<b>Consultation Response from KC, Highways Development Management</b>
<b>2024/93156 Healey Lane Mills, Healey Lane, Healey, Batley, WF17 7SH</b>
<b>REVISED AND ADDITIONAL INFORMATION RECEIVED: Outline application for redevelopment of existing Islamic Centre</b>
<b>Date Responded: 24/03/2026 Responding Officer: CNB Responding Ref: K13-6SW/1</b>

This consultation response is in relation to additional information provided by the applicant in the form of a Pre-commencement parking survey, a completed Stage 1 Road Safety Audit and a phasing diagram. This response should be read in conjunction with the initial response submitted on 11/07/25 and appended below.

**DRAWING REF:** 21185-D02-A **REV:**

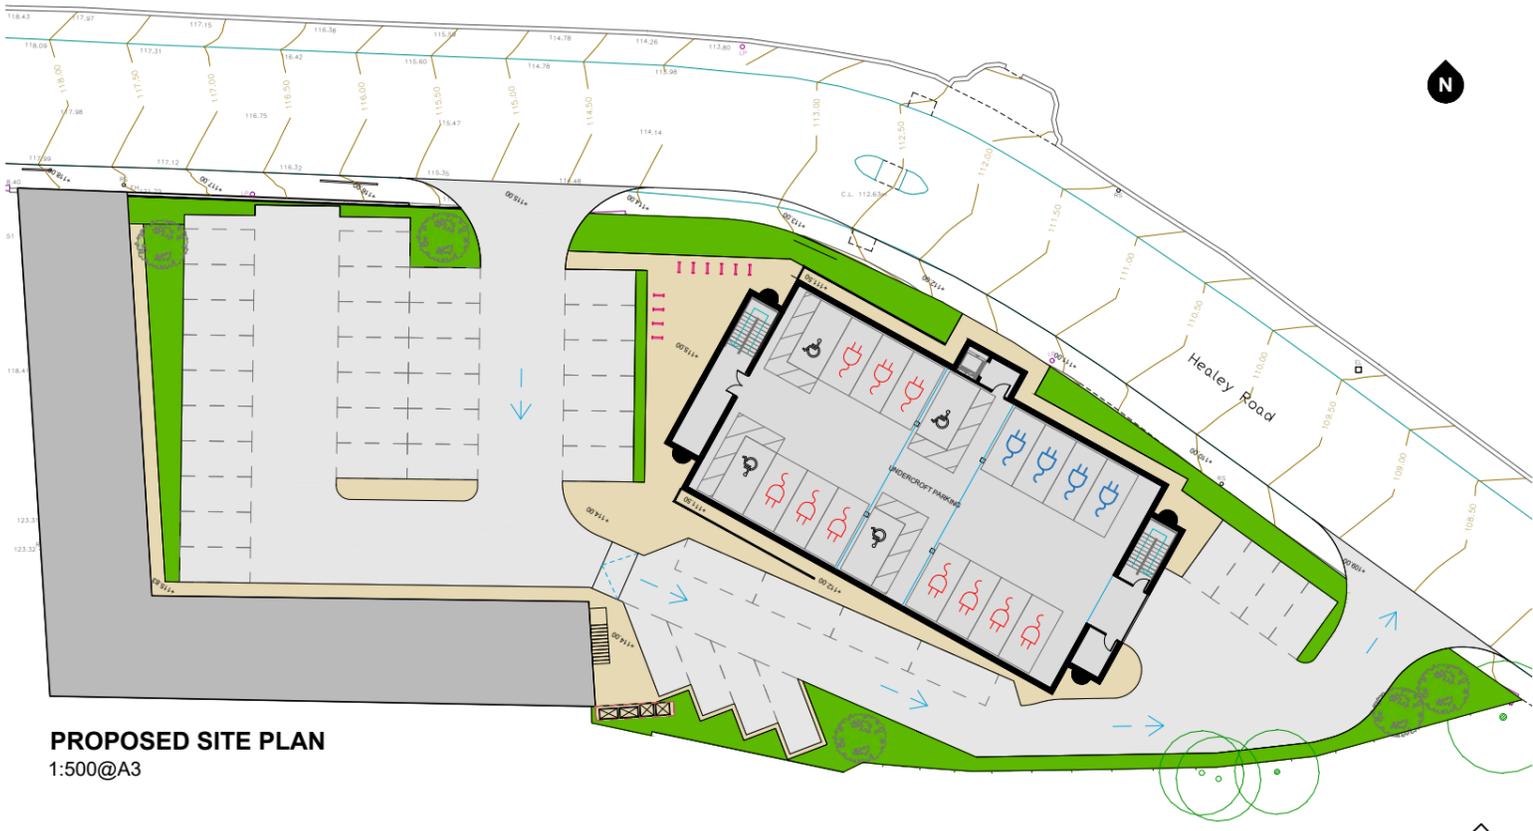
- a. Risk of collision with vehicles turning right in to the site and vehicles travelling westbound – The suggestion was to remove the existing “disabled parking” from adjacent to the access and replace with an extension of the No Waiting At Any Time TRO. This may require an additional fee from the applicant for Kirklees Highway Safety to process the changes to the TRO.

- b. Lack of pedestrian connection between the footway on Healey Lane and the building entrance – The suggestion was to provide a safe pedestrian connection, and this is shown on revised layout drawing No 20185-D02 Rev D.

- e. Drivers failing to observe the one-way system – The suggestion was to reduce the widths of the access, however this would remove the safe access for a refuse vehicle to serve the development site and so the designer's response was to include suitable signs and markings to reinforce the one-way system.

- f. The pedestrian desire line between the two buildings is across a ramp leading to increased trips/falls – the ramp was removed from the design as shown on revised layout drawing No

- g. Poor intervisibility between drivers entering and leaving the under-croft car park and the use of warning signs should be employed – The designer’s response was the vehicle speeds would be low and that a car parking management plan can be conditioned to effectively manage the car park to avoid this safety concern.
- h. Risk of servicing vehicles undertaking reversing manoeuvres within the site and recommended a servicing is adequately managed – The applicant agreed to a servicing management plan being conditioned.

20185-D02 Rev D.

HDM agreed with the designer’s responses and approved these actions, and they should be conditioned where possible and revised layout drawing No 20185-D02 Rev D included in the approved drawings list.
